WSA Reference: WSA25.008

1953-2109 Elizabeth Drive, Badgerys Creek

SSD70817958

Thank you for the opportunity to comment on the State Significant Development Application (SSD70817958) for the northern portion (Stage 2) of the DHL Logistic Facility, located at 1953-2109 Elizabeth Drive, Badgerys Creek. We understand that the proposal comprises:

Drawing Number
S2-801 C

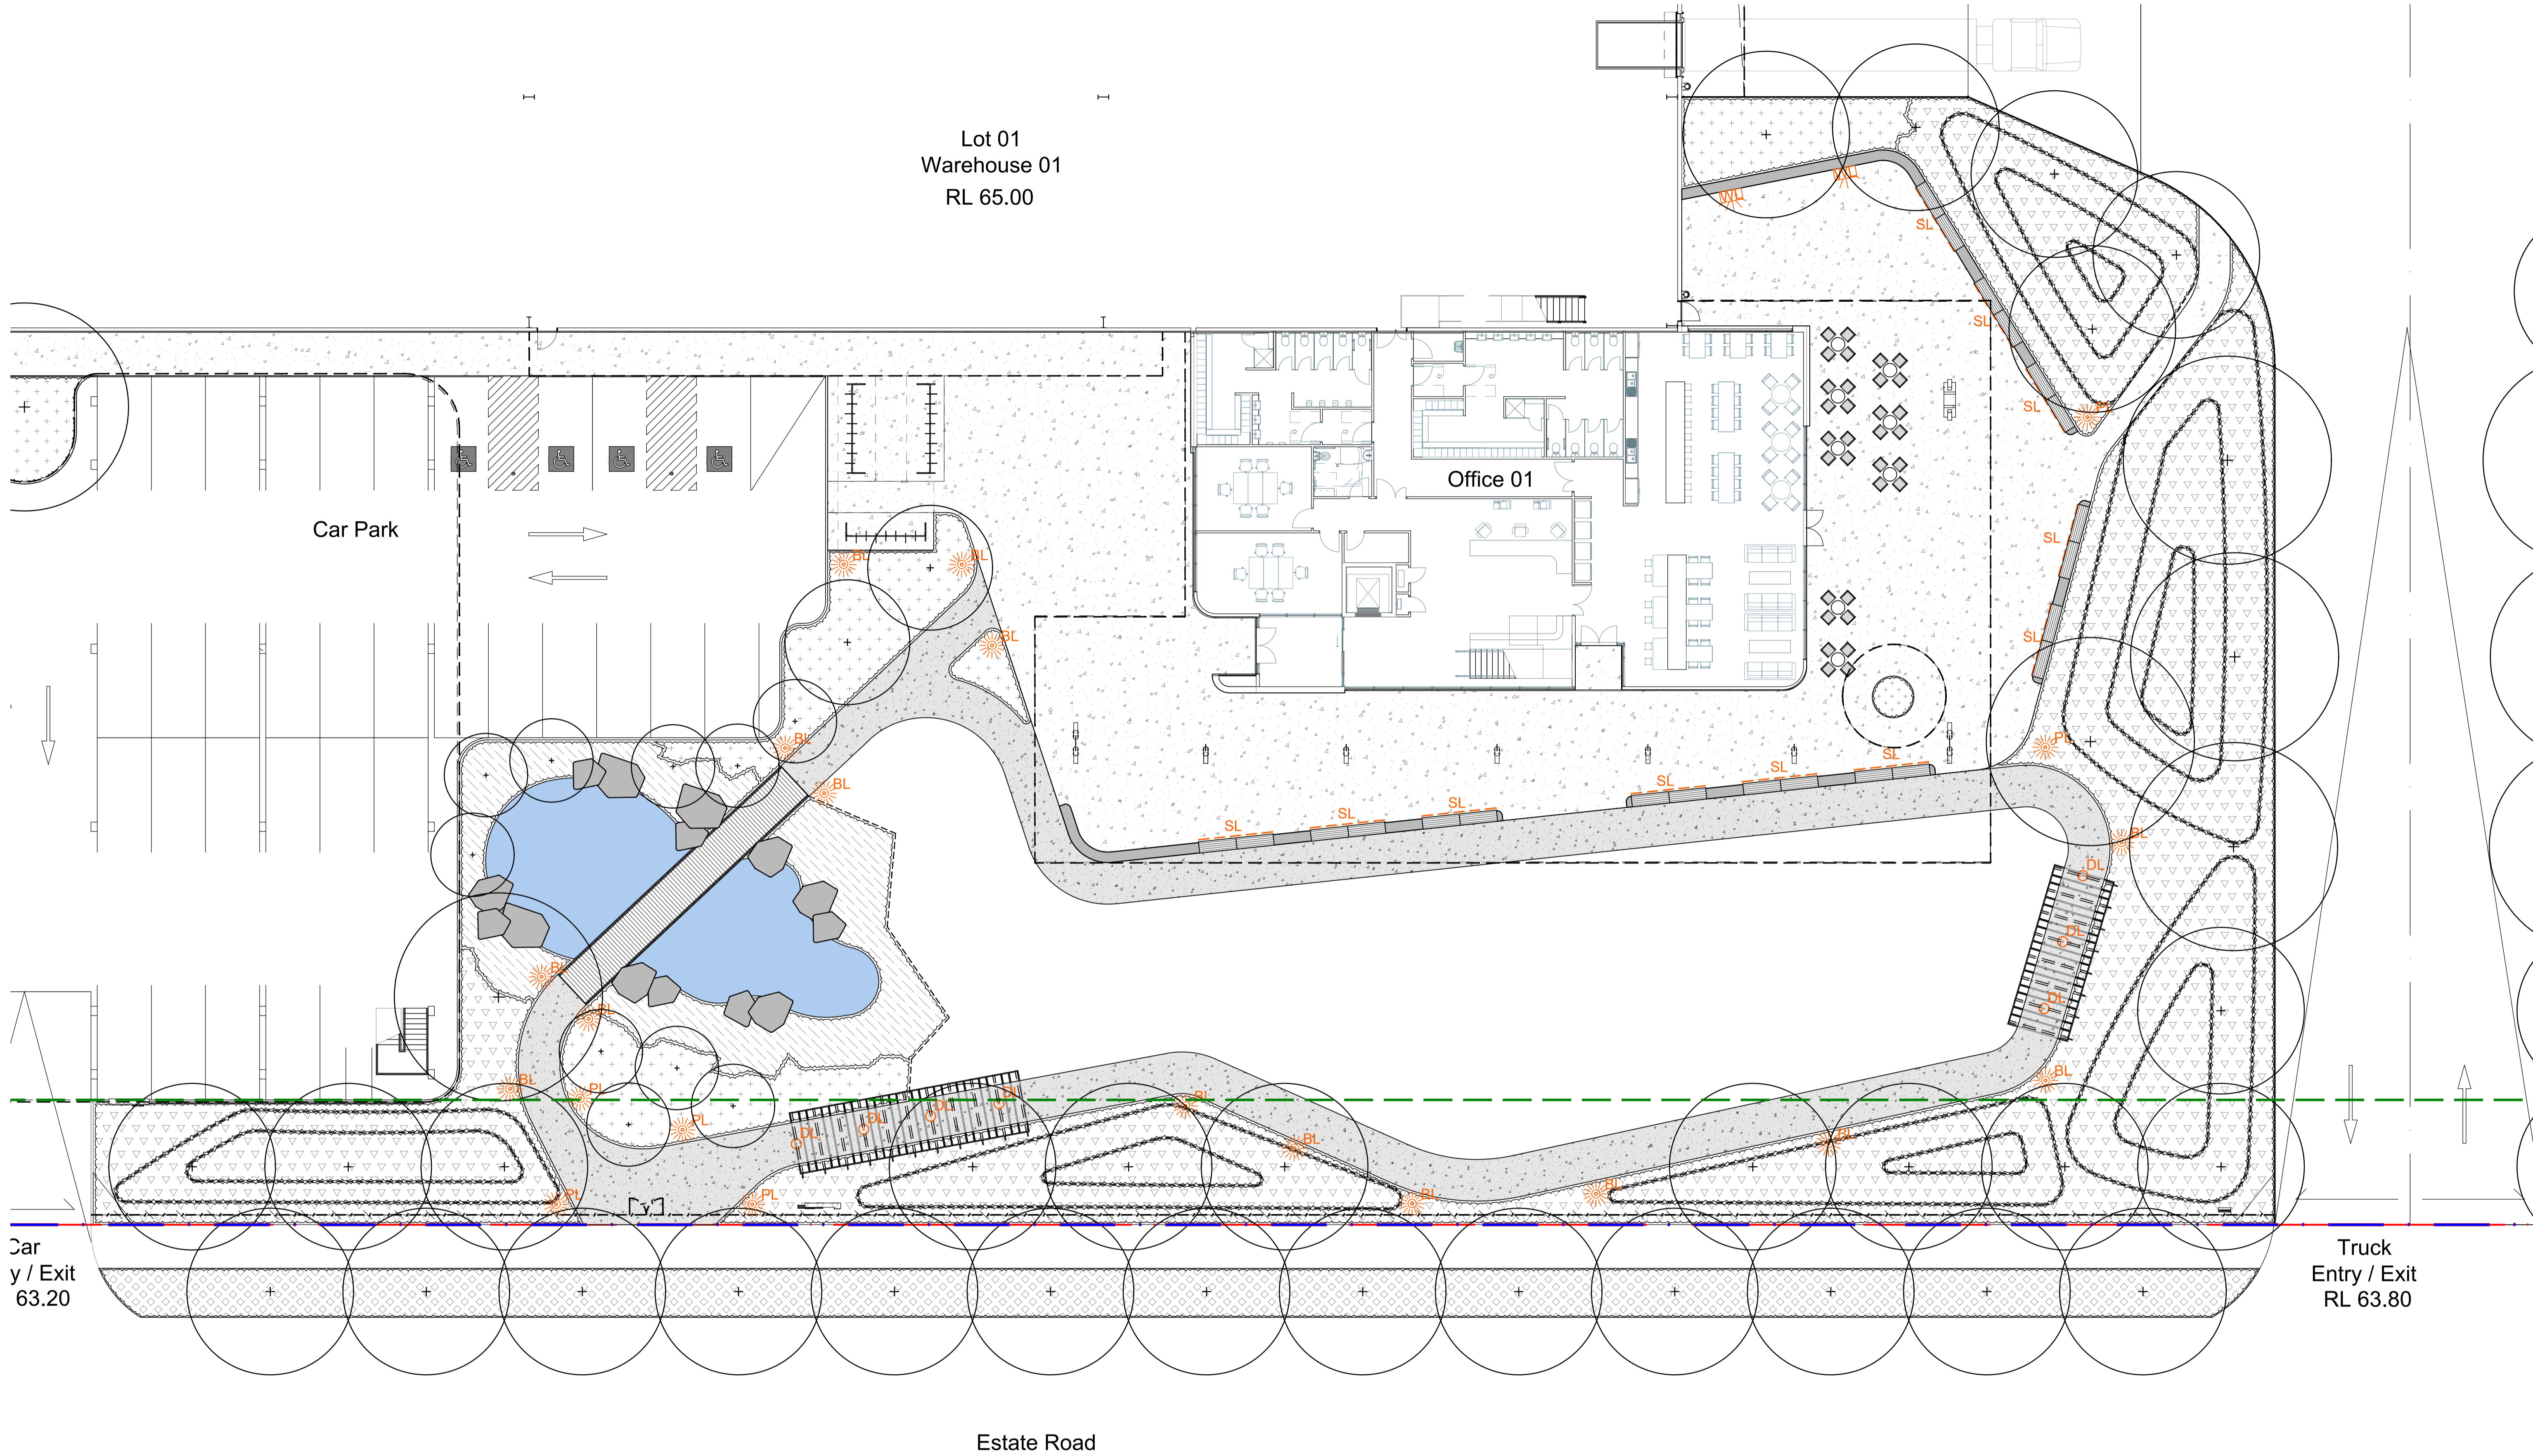
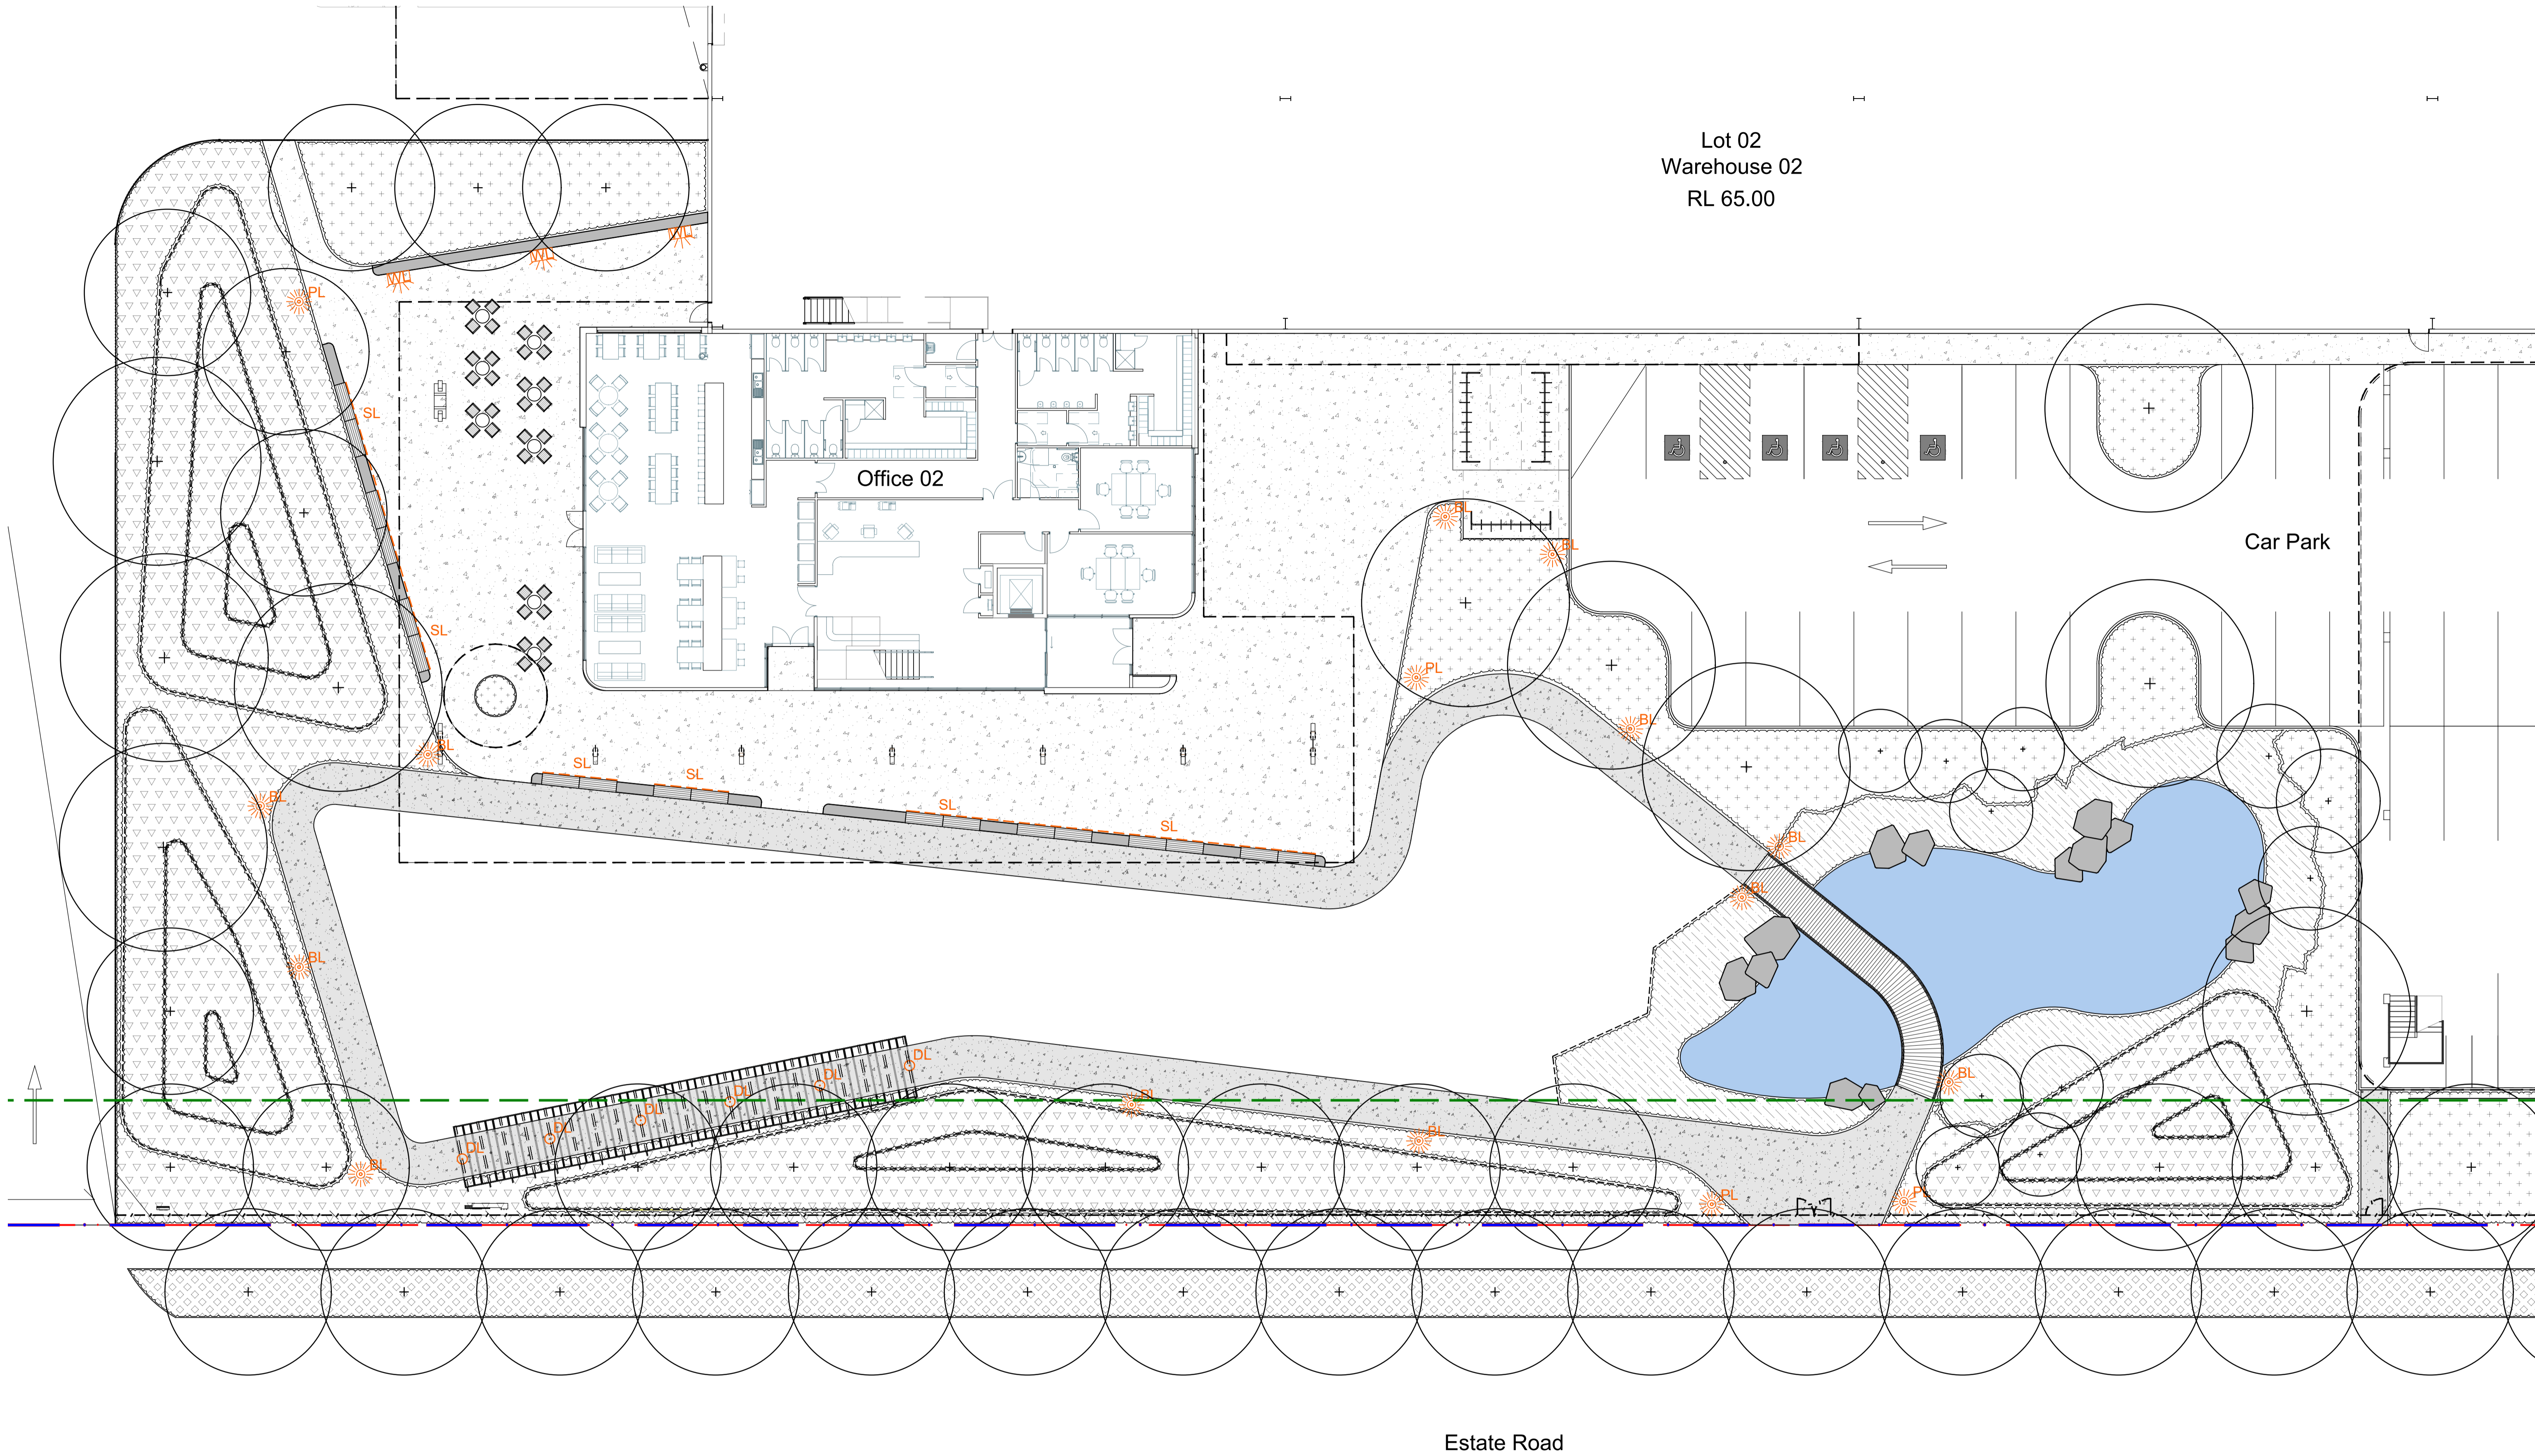
<p>Lighting</p>	
<p>Development is within the Lighting Control Zones / Lighting Intensity Radius Area</p>	<p>The site includes areas located within Lighting Control Zones C and D and is wholly situated in the 6km Lighting Intensity Radius. Lighting on the site must not exceed an intensity of light for Zone C – 150 cd, and for Zone D – 450cd above the 3-degree horizontal plane.</p> <p>External lighting is to be fitted with a screen/shroud that prevents the light emission above the horizontal plane. A condition of consent should be imposed to this effect.</p>
<p>Where construction lighting is likely</p>	<p>Any construction lighting should be detailed post approval, including measures to ensure that lighting used in construction does not point upwards or potentially result in risk to pilots. A condition of consent should be imposed to this effect.</p>
<p>Airspace Operation</p>	
<p>OLS</p>	<p>Based on the information provided it appears that the height of the development is below the OLS. However, there is inconsistent height of buildings information detailed in the EIS. For example, the AIA needs to undertake an assessment based on the overall height including the air conditioning units.</p>

TITLE		PROJECT NO.		DWG NO.		REVISION	
ELEVATIONS & SECTION - STAGE 2		21254	DA200	4			
DATE	SCALE						
28/02/2025	1:750 @ A1 1:1500 @ A3

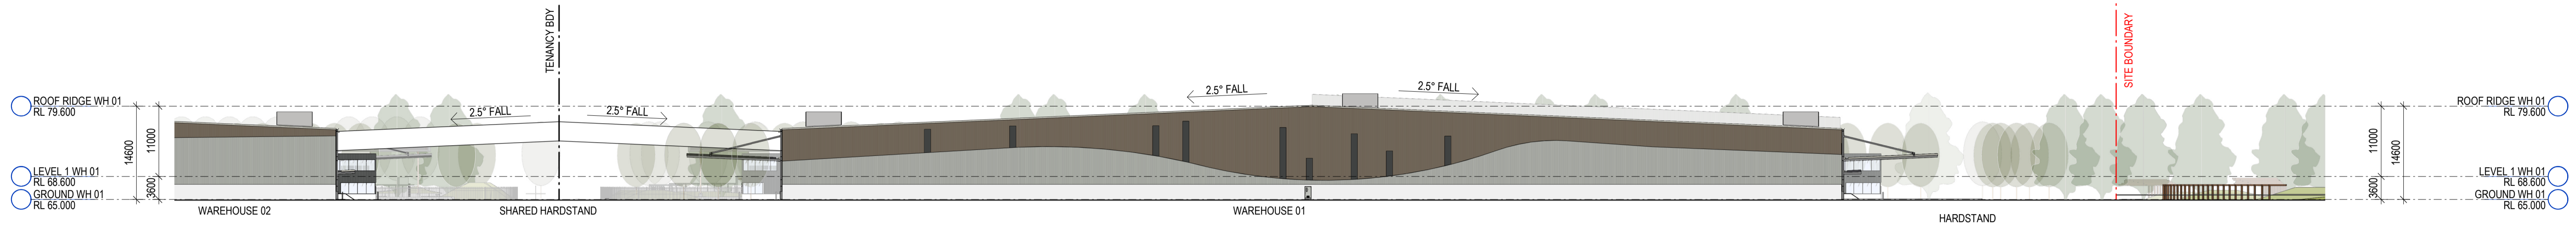
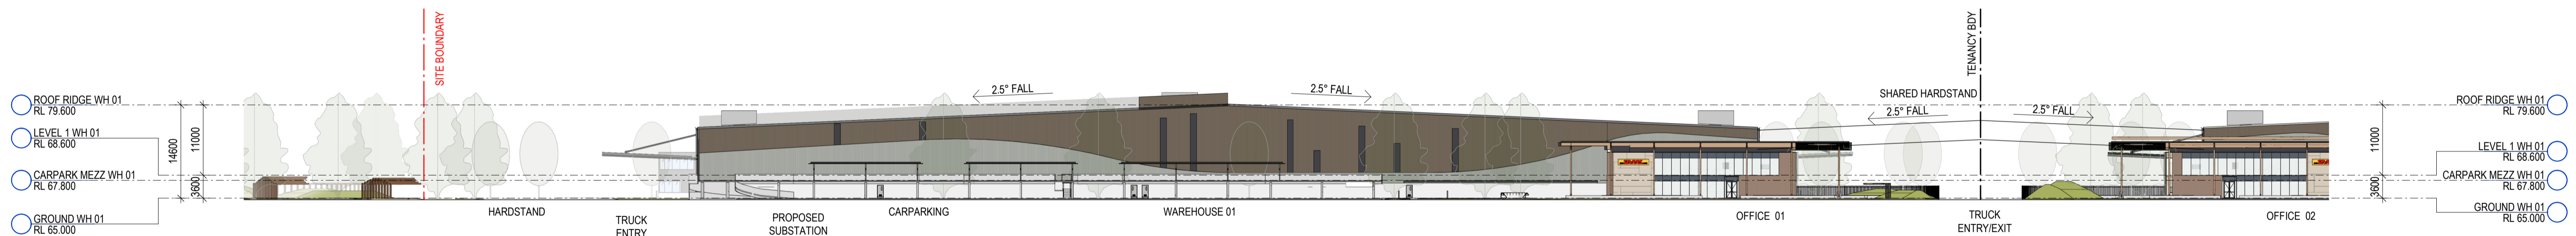
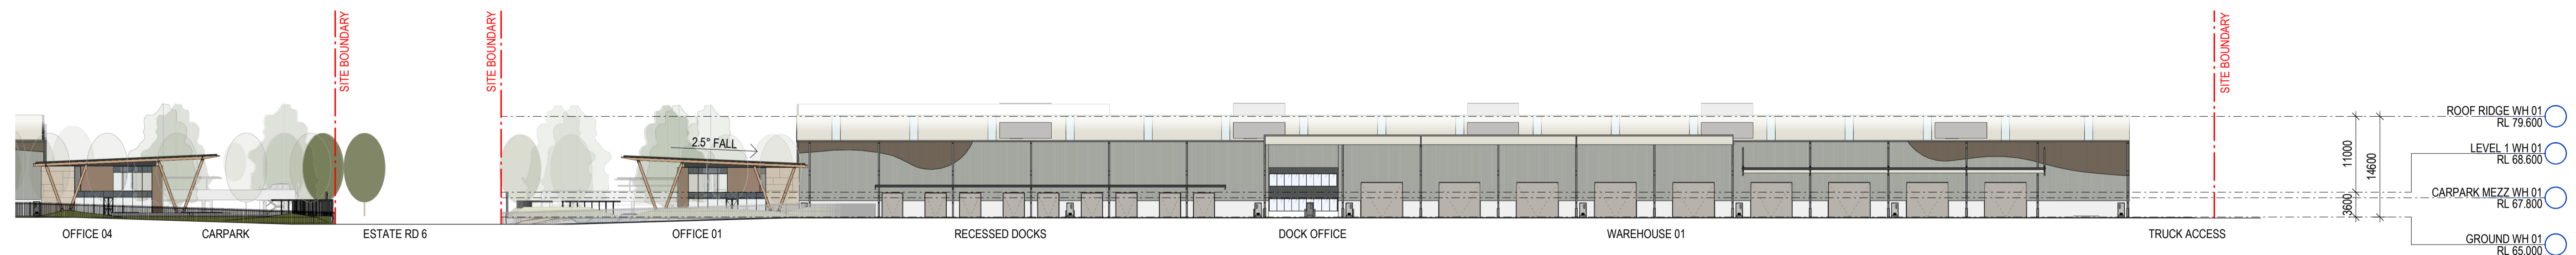
Glide Path Building Restricted Area	
<p>Proposal is in Glide Path Restricted Area, as shown in the Western Sydney Airport Plan</p>	<p>A small portion of Warehouse 2 is within the Glide Path Trigger Assessment Area, assessment should be included in regard to the Glide Path Building Restricted Area.</p> <p>The EIS/AIA notes that Airservices Aust needs to be consulted, and it appears this has not been done by the applicant to date. The AIA indicates that consultation was undertaken with CASA, Airservices and WSI, however there no details documented in Table 1.</p>
